Our Ref: R/2019/22/C
File No: 2021/222315
Your Ref: SSD-10382

Rodger Roppolo
Senior Planning Officer – Key Sites Assessments
Department of Industry, Planning and Environment

Revised Response to Submissions – Student Accommodation, 90-102 Regent Street, Redfern (SSD-10382)

LEVEL 3 | LANDSCAPE PLAN

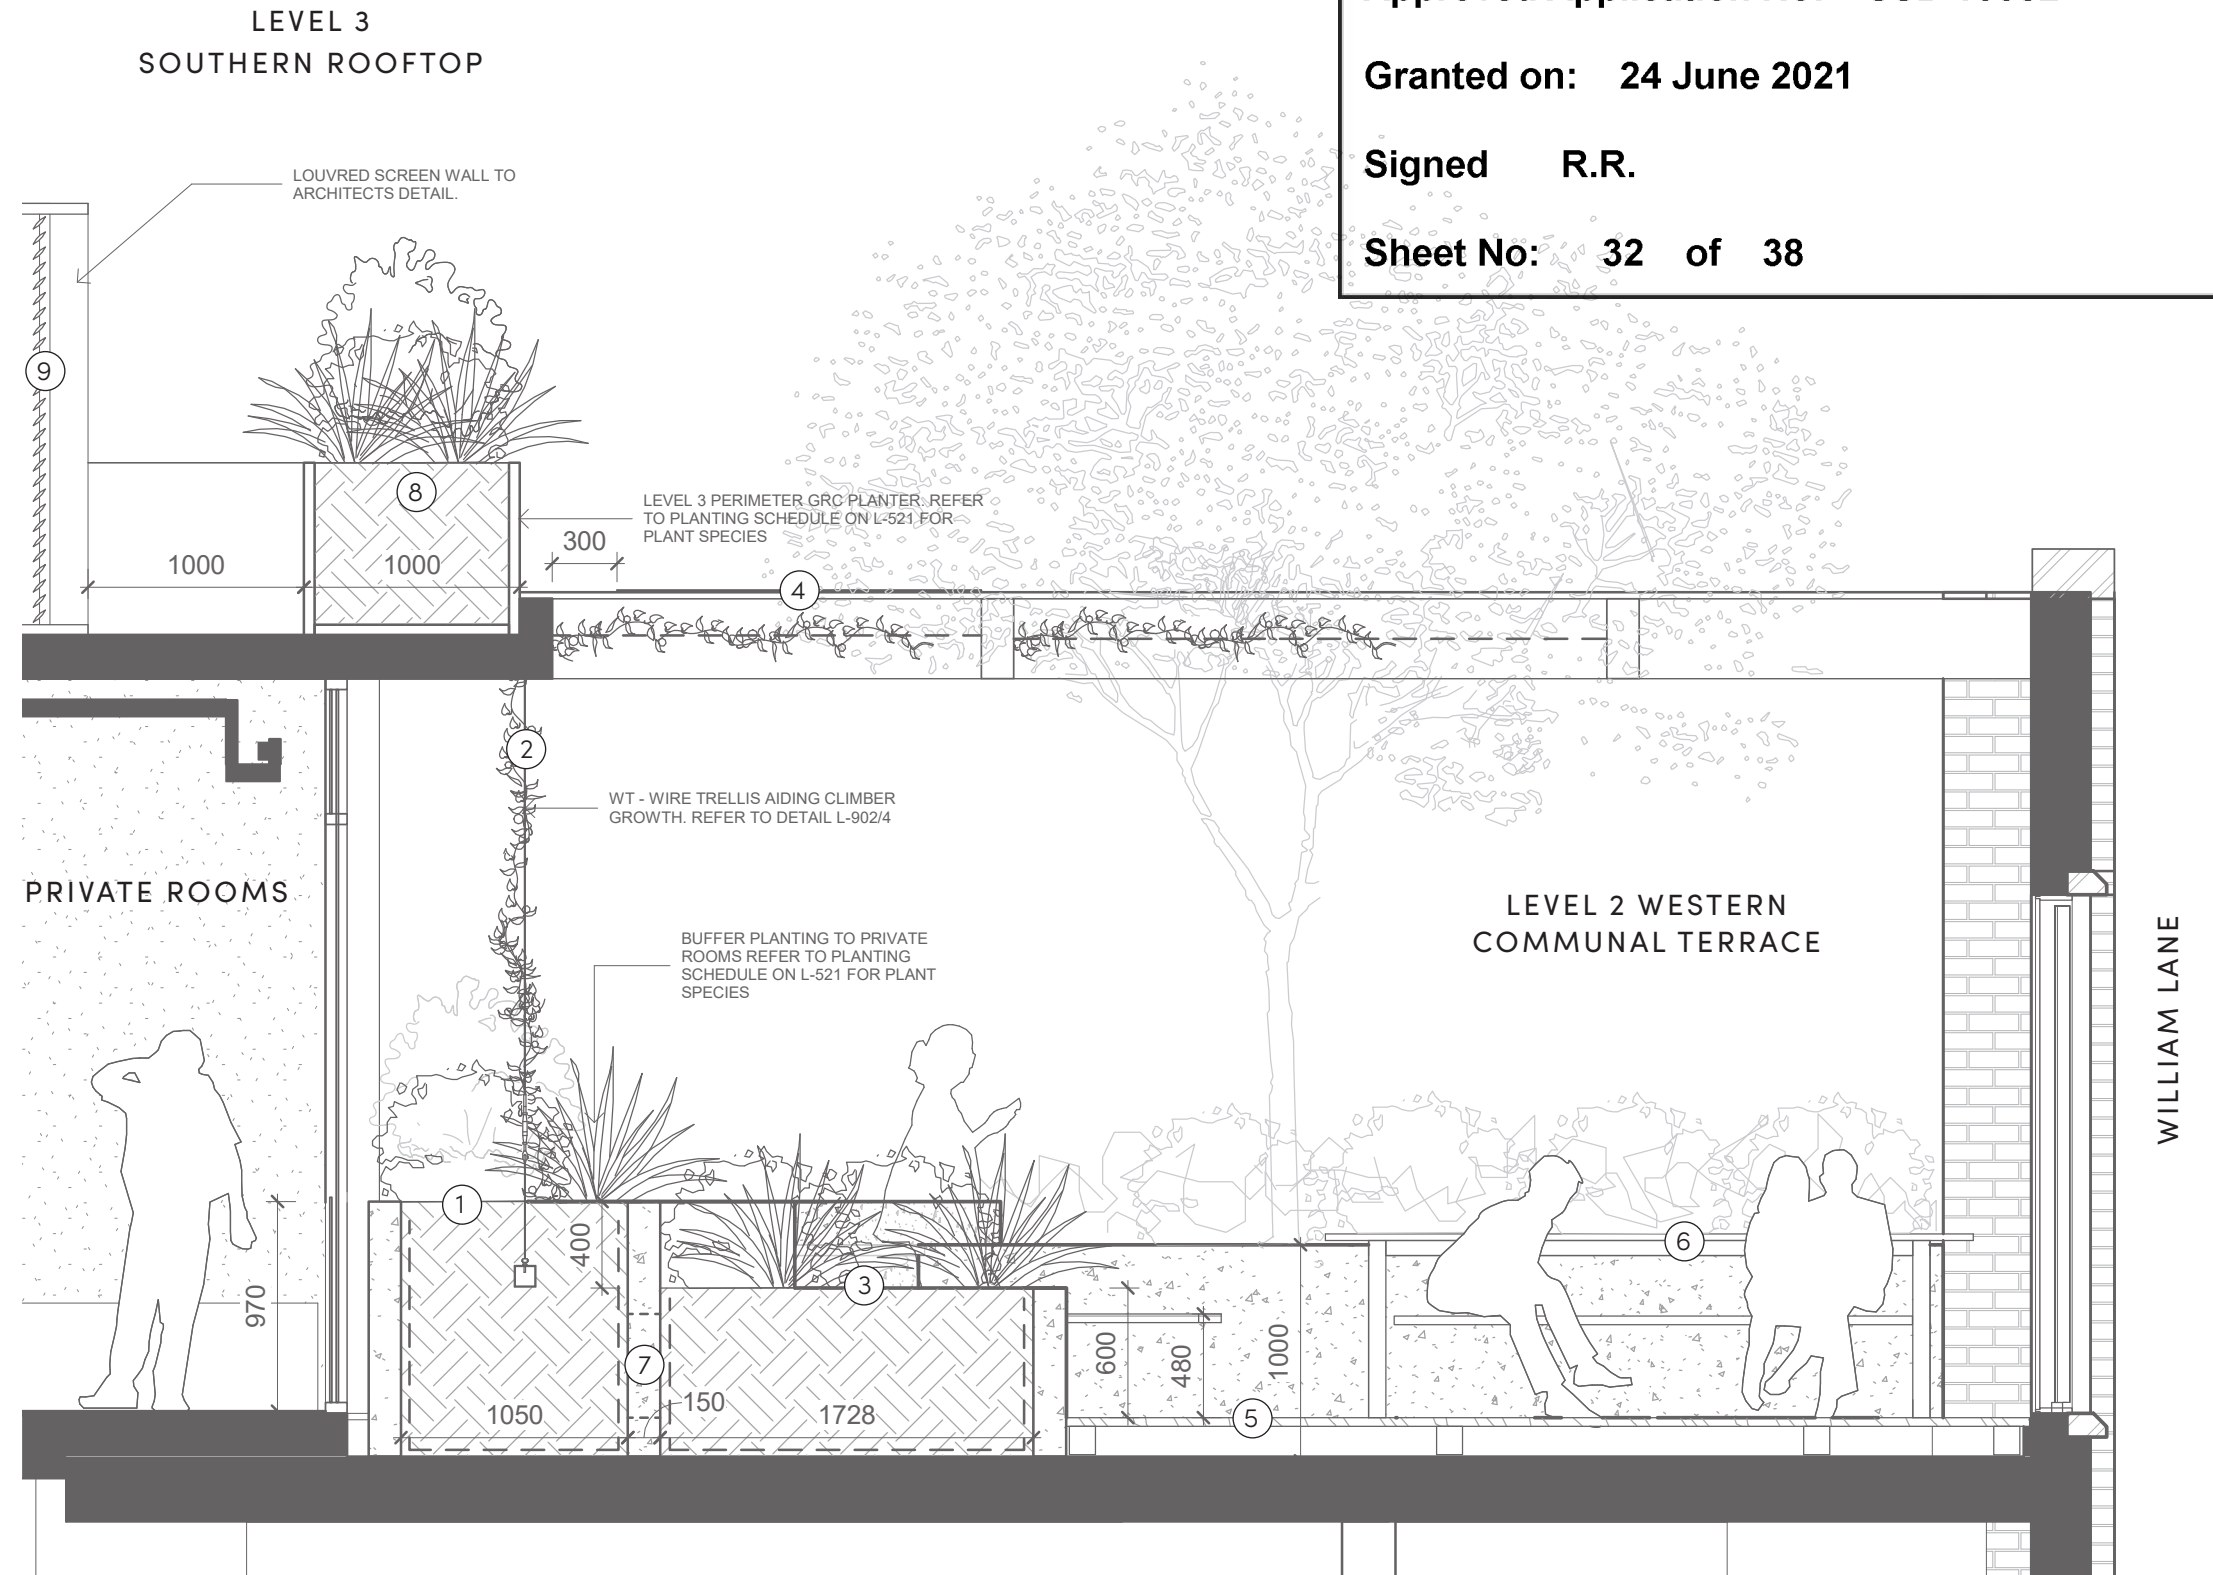
The three '*Tristaniopsis laurina* – Small' within the Level 3 rooftop must be replaced with one medium sized tree and the rooftop terrace amended to be a garden bed that provides soil volumes consistent with the Sydney Landscape Code.

## SOIL DEPTH PLAN | LANDSCAPE

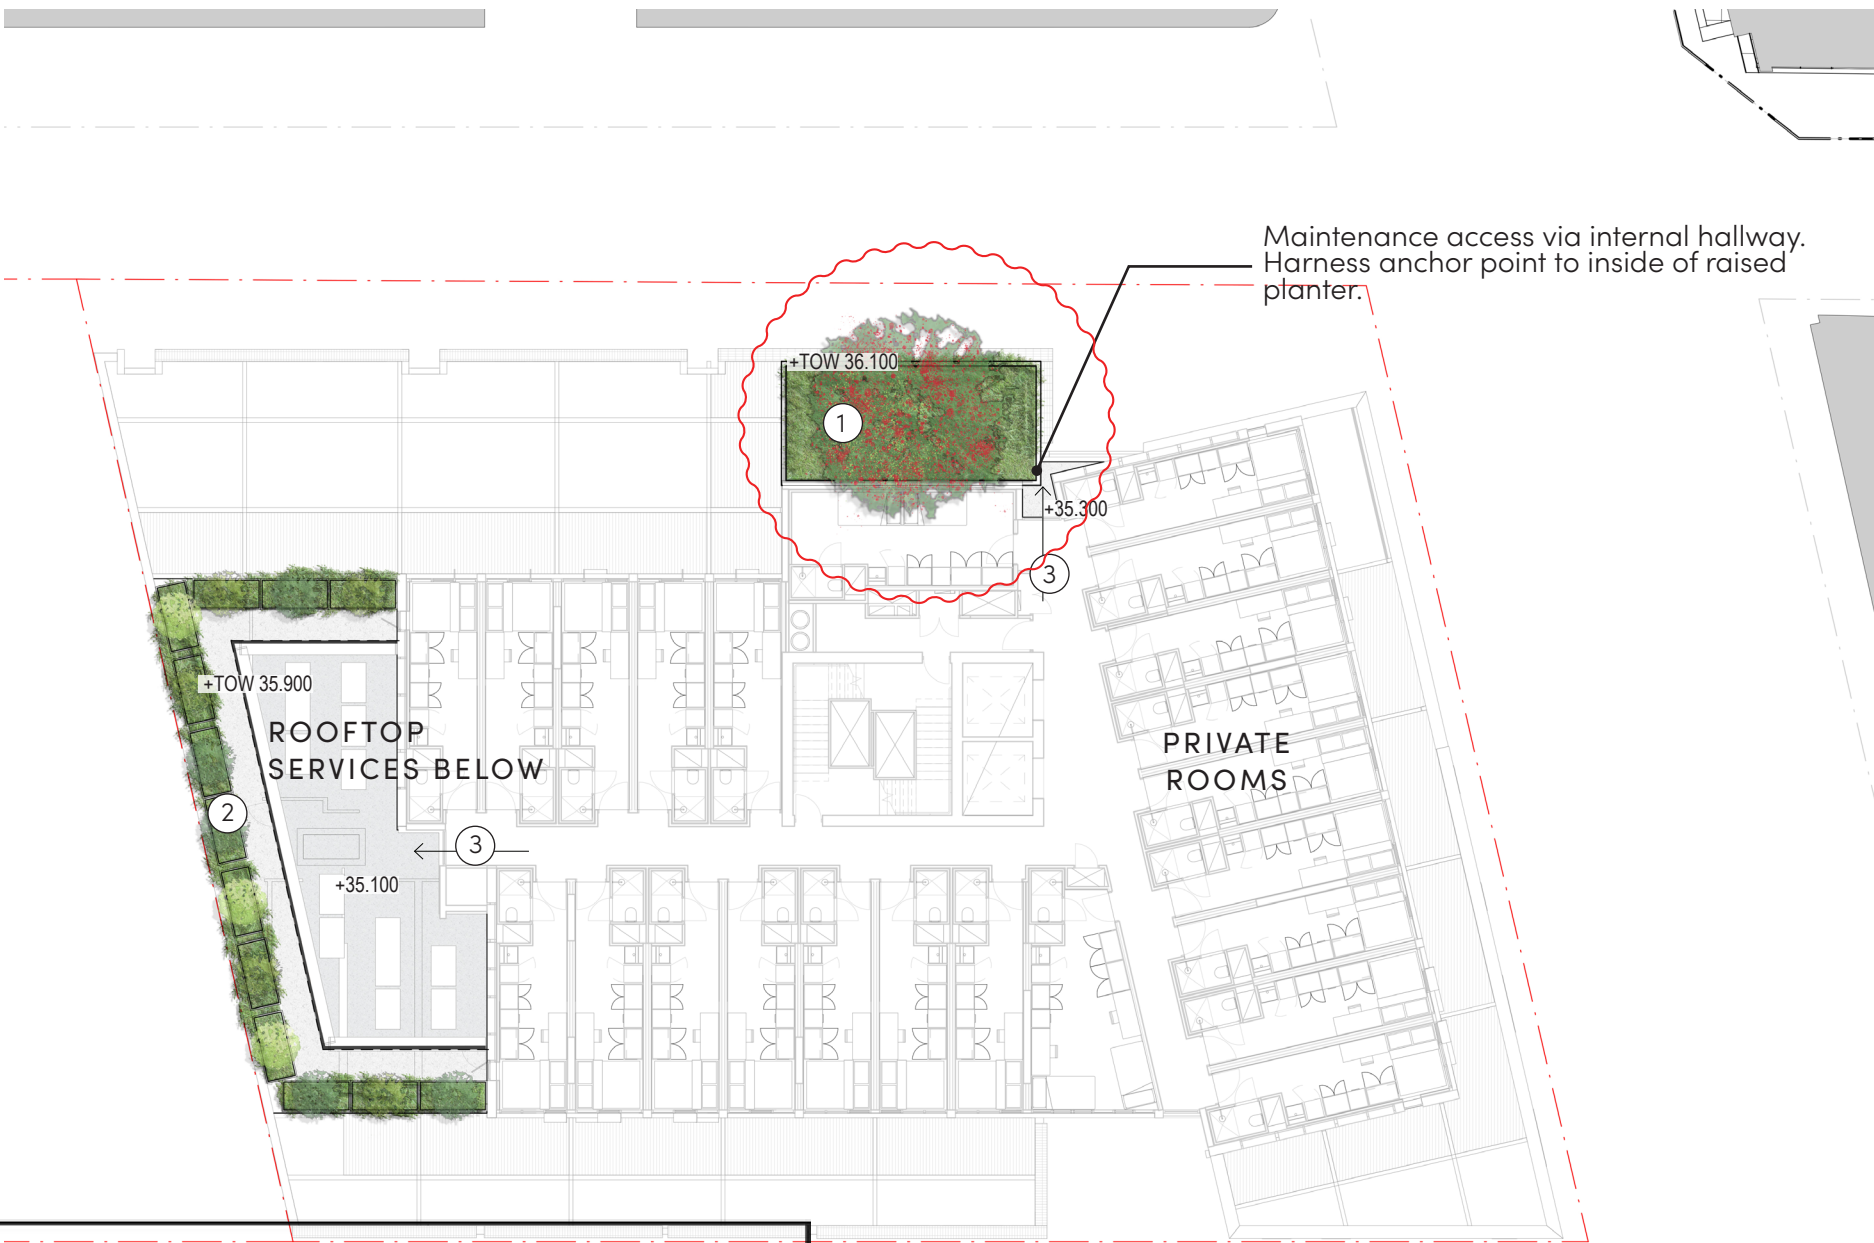
The planting of new trees in raised planters must be provided with adequate soil depth and volume in accordance with Sydney Landscape Code. This is to ensure the trees do not become stunted but reach their full genetic potential and provide the maximum amount of canopy coverage at maturity.

The garden beds proposed on Level two are not large or deep enough to sustain trees and must be amended to provide adequate soil volumes for the planting of trees as laid out within the Sydney Landscape Code. The smaller raised planters should be consolidated and made contiguous to allow for the soil volume and depth that can sustain mature trees.

### LEVEL 2

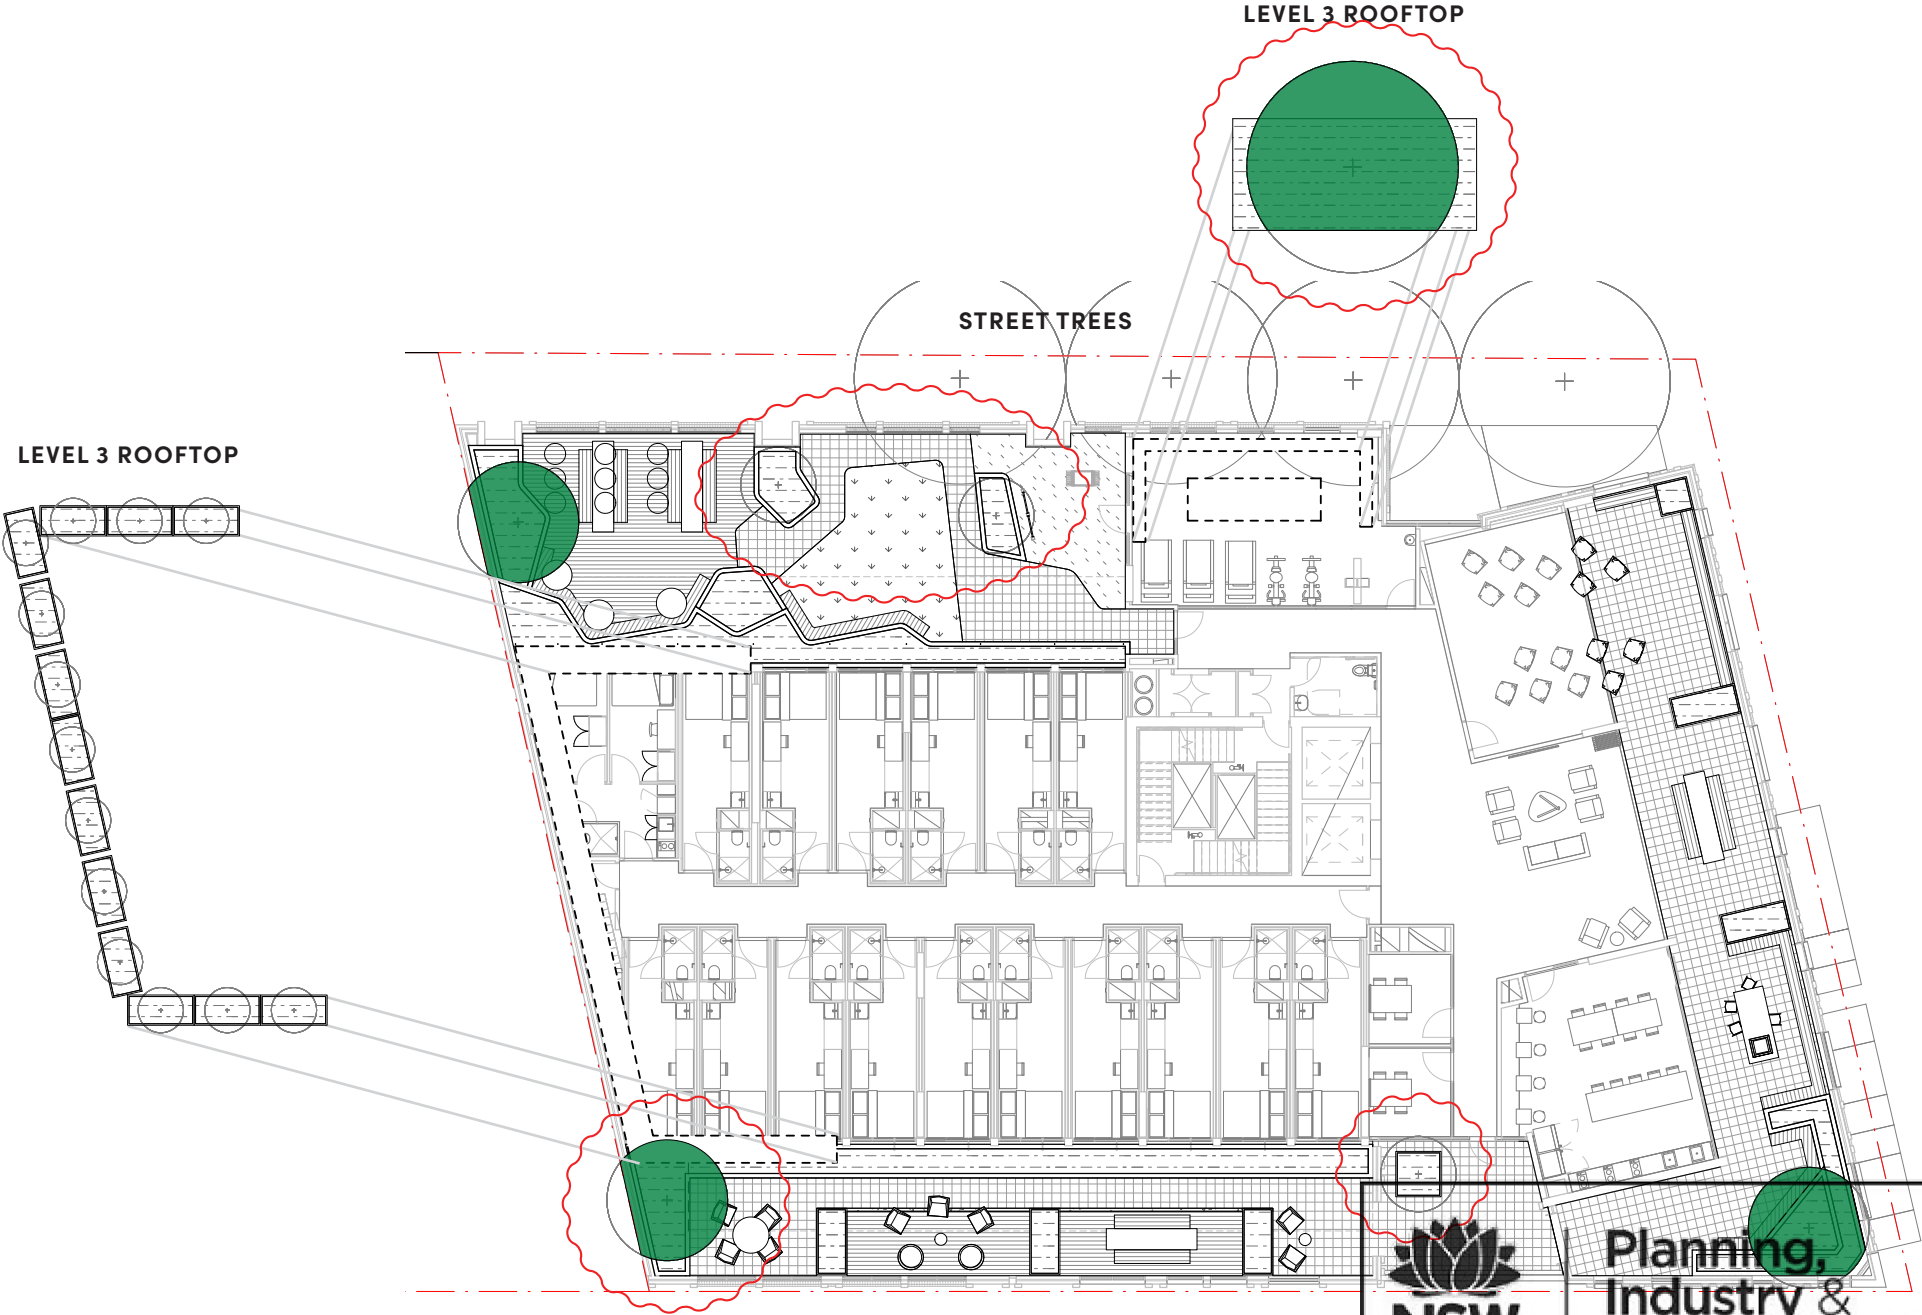
Generally, there has been limited response to the previous concerns raised by the City in earlier iterations of this development. The proposed landscaping continues to be limited. The 15% canopy coverage requirement within 10 years of completion as prescribed under Sydney DCP 2012 will not be met. The canopy coverage from street trees within Council land does not count towards the canopy provided from the site. Specifically, the *Syzygium 'aussie sothern'* located on the level 3 roof top and the *Tristaniopsis laurina* are not of a size that would require their retention and protection under Sydney DCP 2012 and, therefore, do not contribute to the canopy cover of the site. The landscape plans must be amended to provide the required 15% canopy cover under the Sydney DCP 2012 controls.
